From: Brian Banister <[REDACTED]>
Sent: 19 March 2025 12:58
To: Planning.Responses
Subject: Arun Conservation Area Advisory Panel comments on applications

The **Arun Conservation Area Advisory Panel** wish the following comments to be taken into consideration in the determination of the applications:

Y/15/25/PL and Y/16/25/L - Stakers Farm, North End Road, Yapton

DRAWING TITLE
 PROPOSED ELEVATIONS

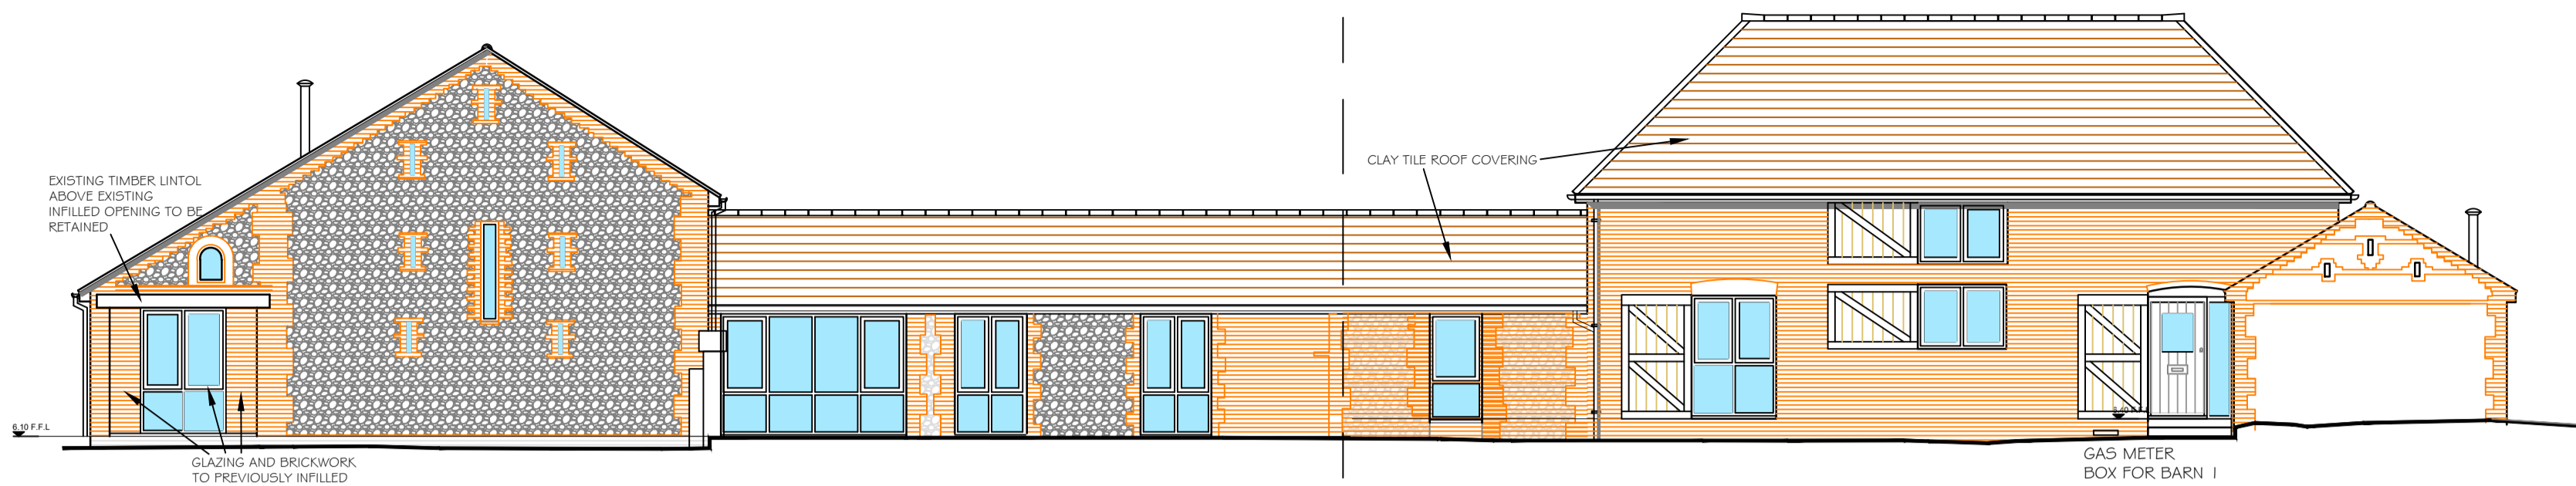
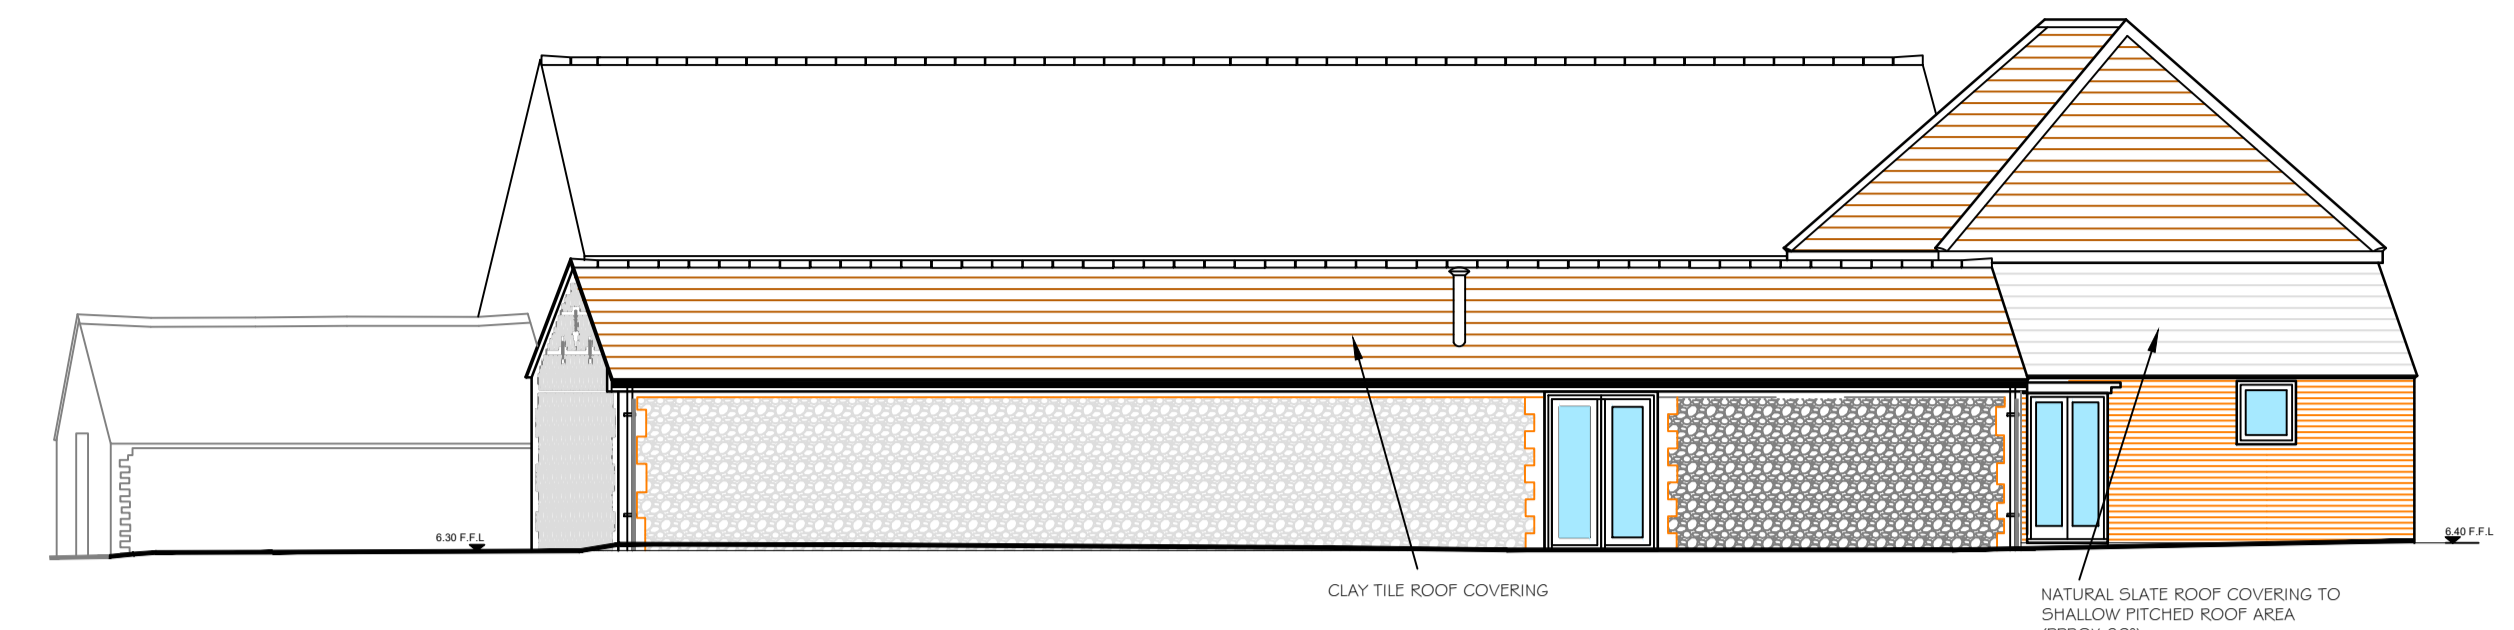
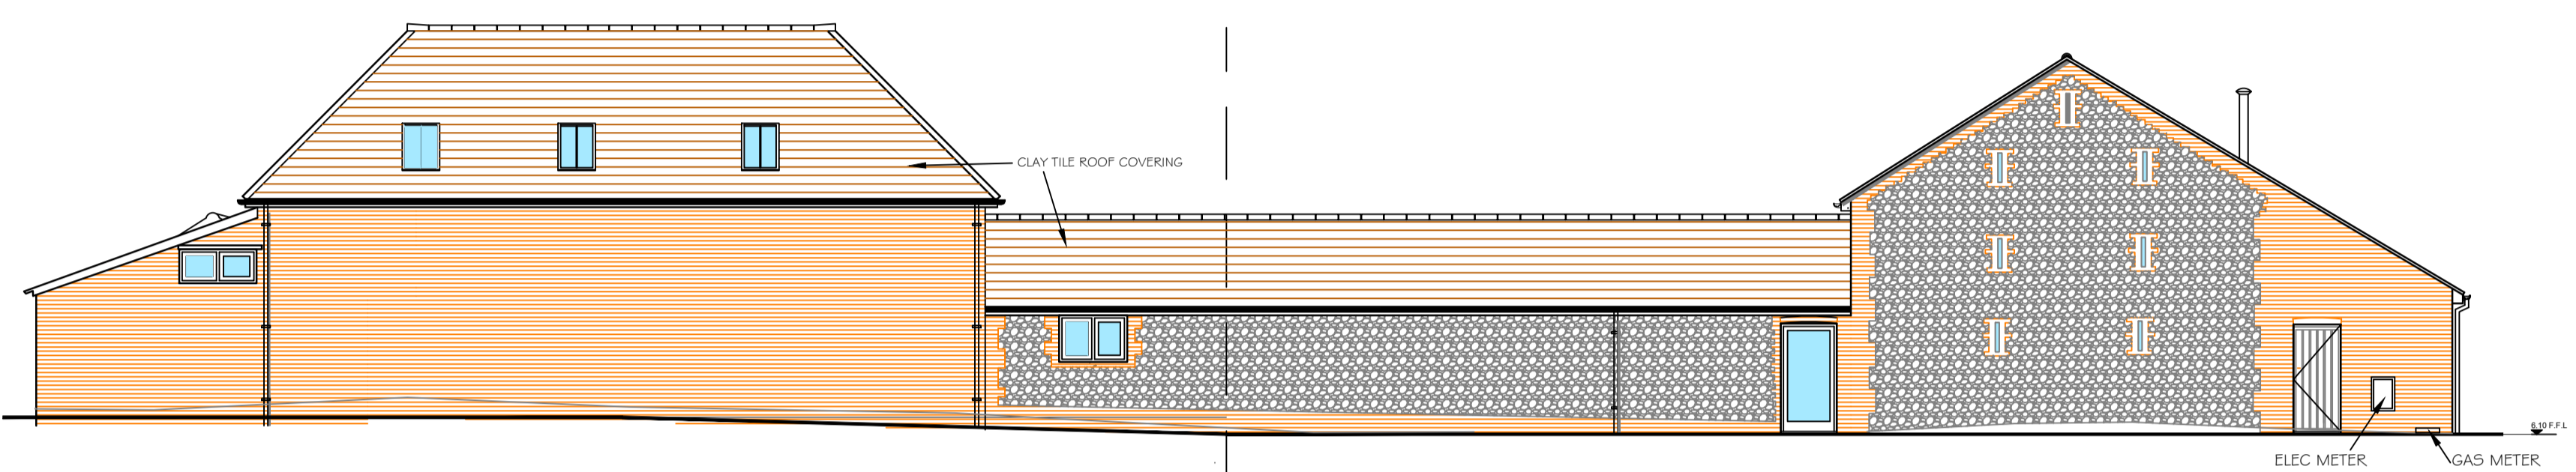
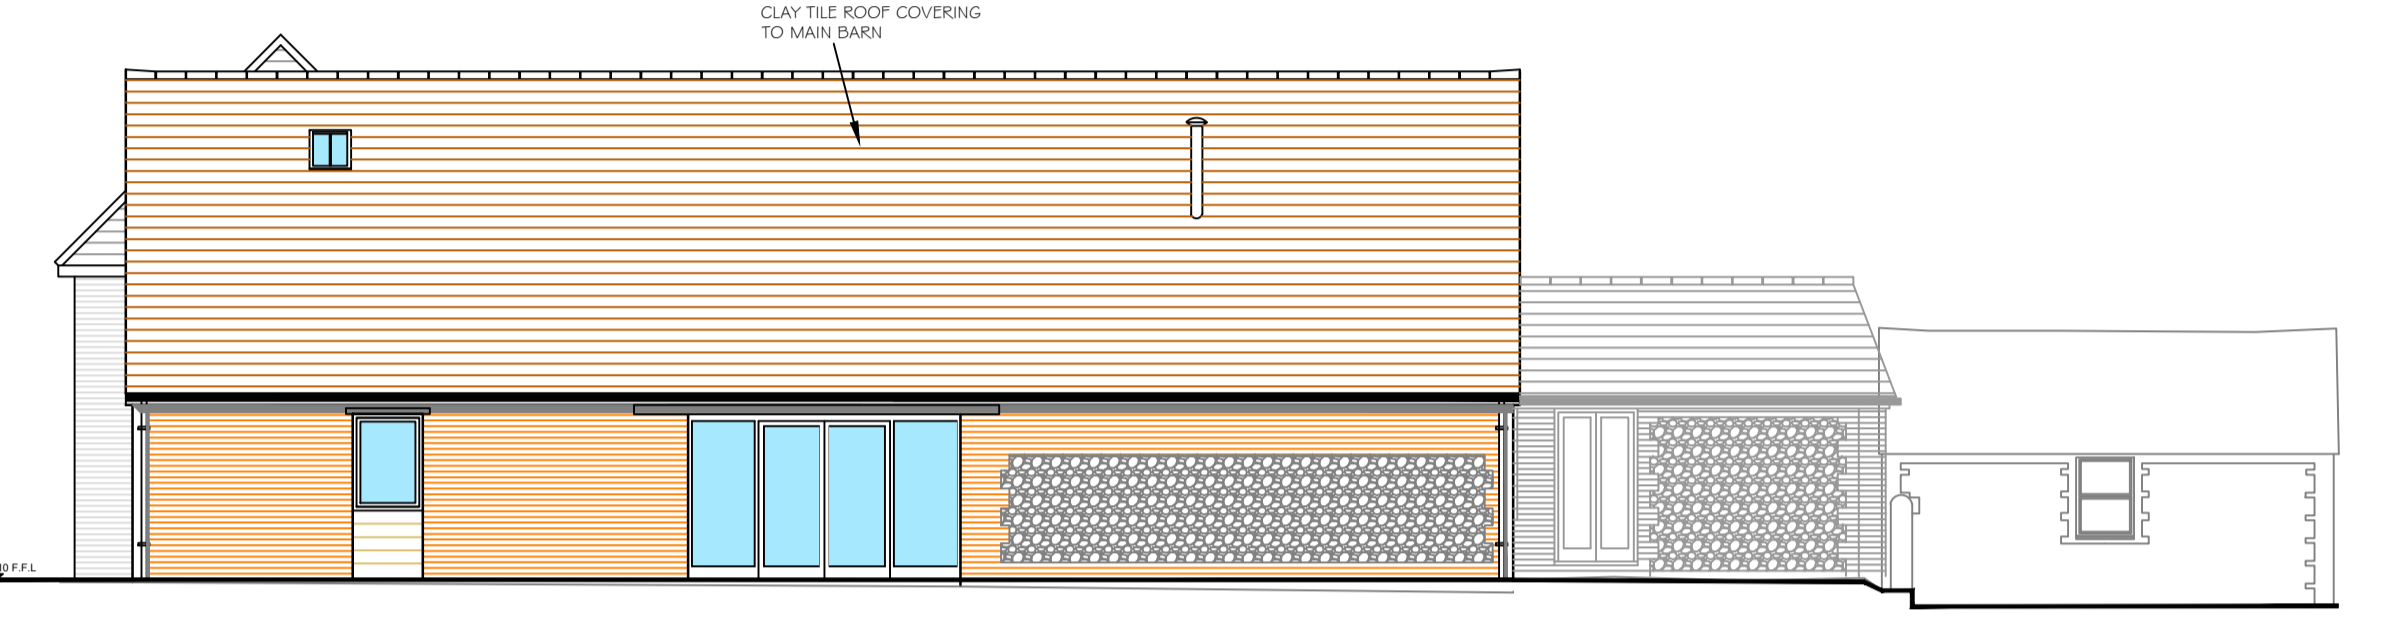
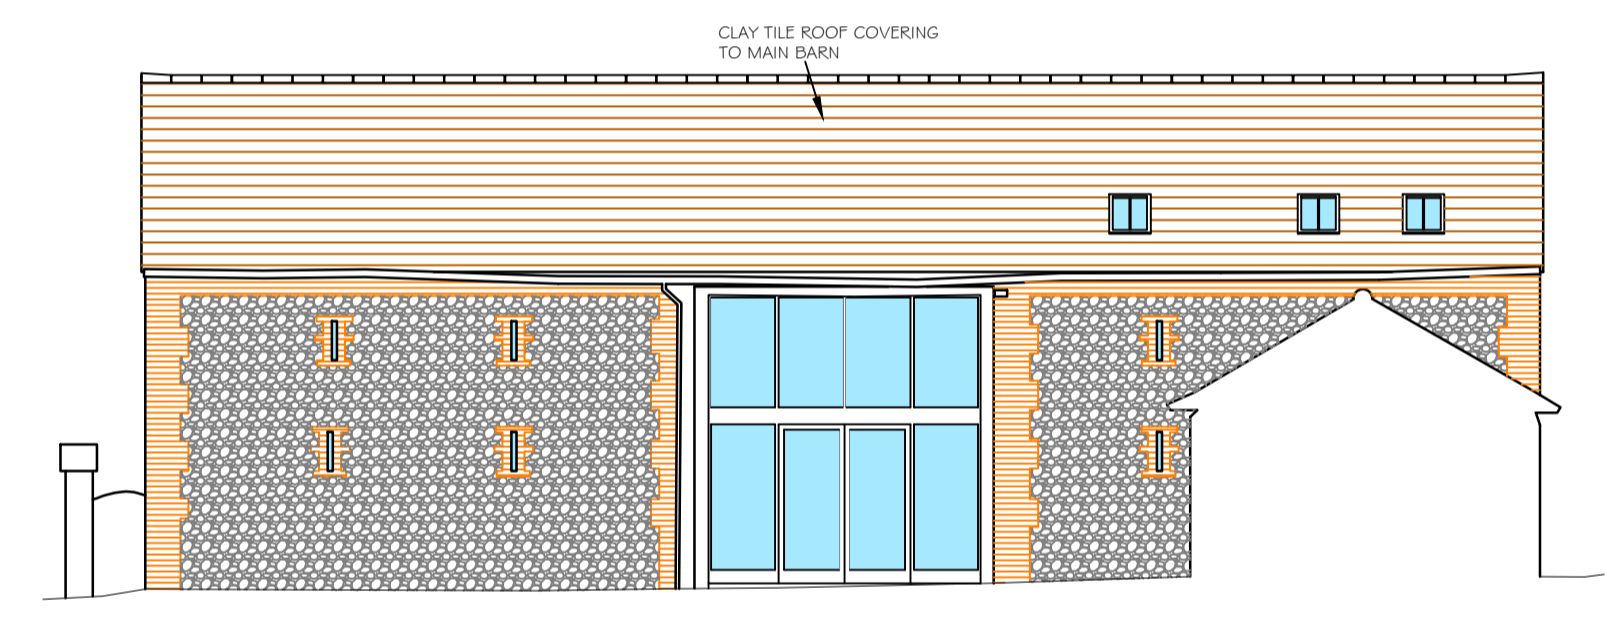
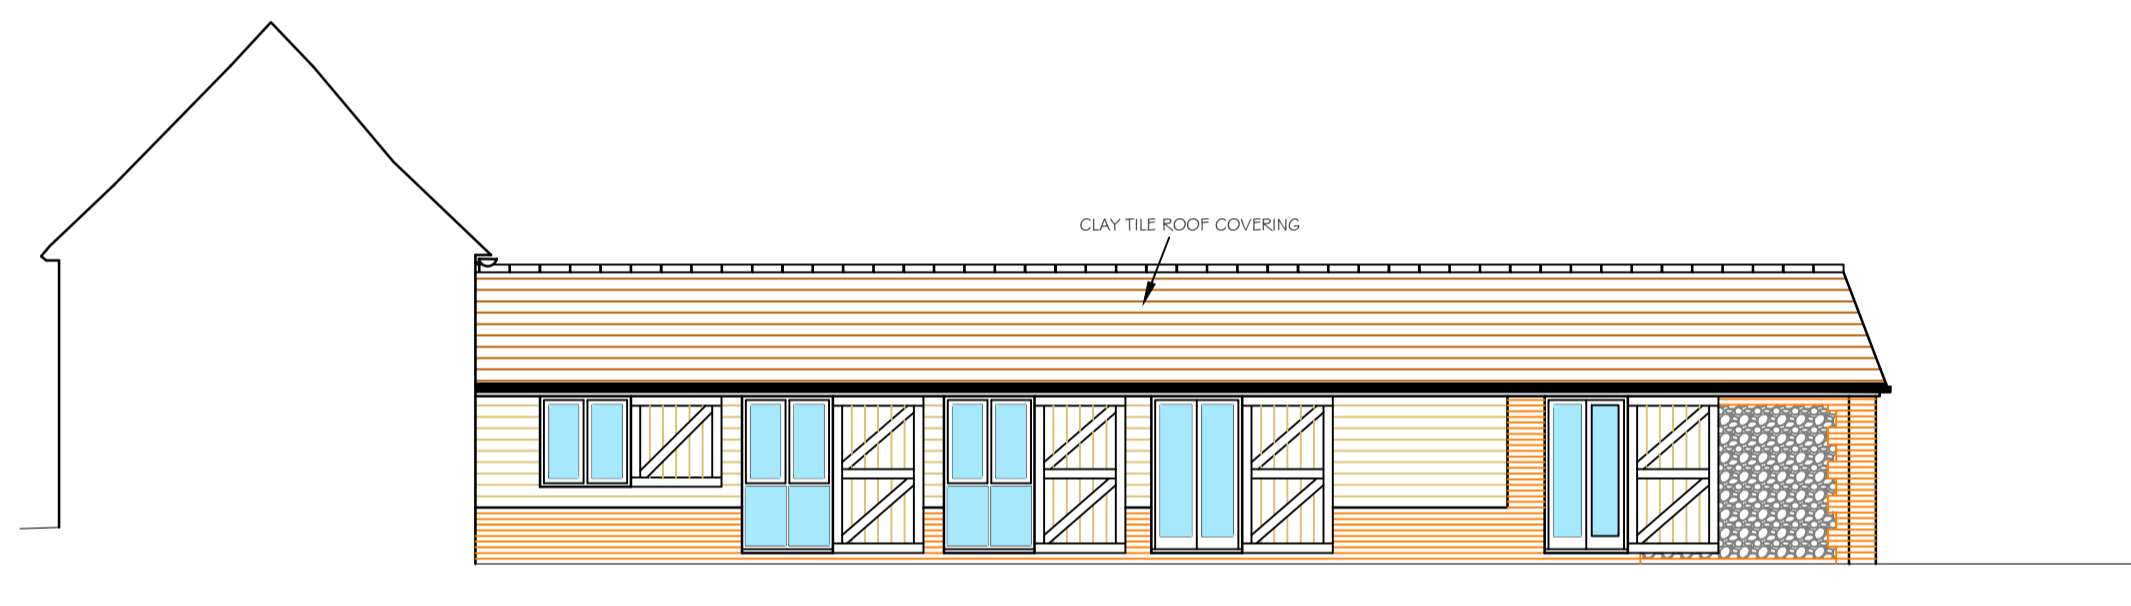
The Panel consider that the proposed fenestration needs significant improvement in design and appearance. It currently appears overly domestic in appearance and does not reflect the nature and character of the specific building types.

It also queries the need to totally replace the clay roof tiles to the main buildings albeit in a very high quality clay tile. Total replacement will mean the loss of the patina which is an attractive feature of the buildings. If, however, there is a proven need to replace the existing tiles in order to better protect the structures for the future then clearly the Panel would not object in that instance.

The same clay roof tile to be used on the existing buildings also needs to be used on the roofs of the new outbuildings and the exact colour and tone of the stain to be used in the fenestration of the buildings also needs to be established.
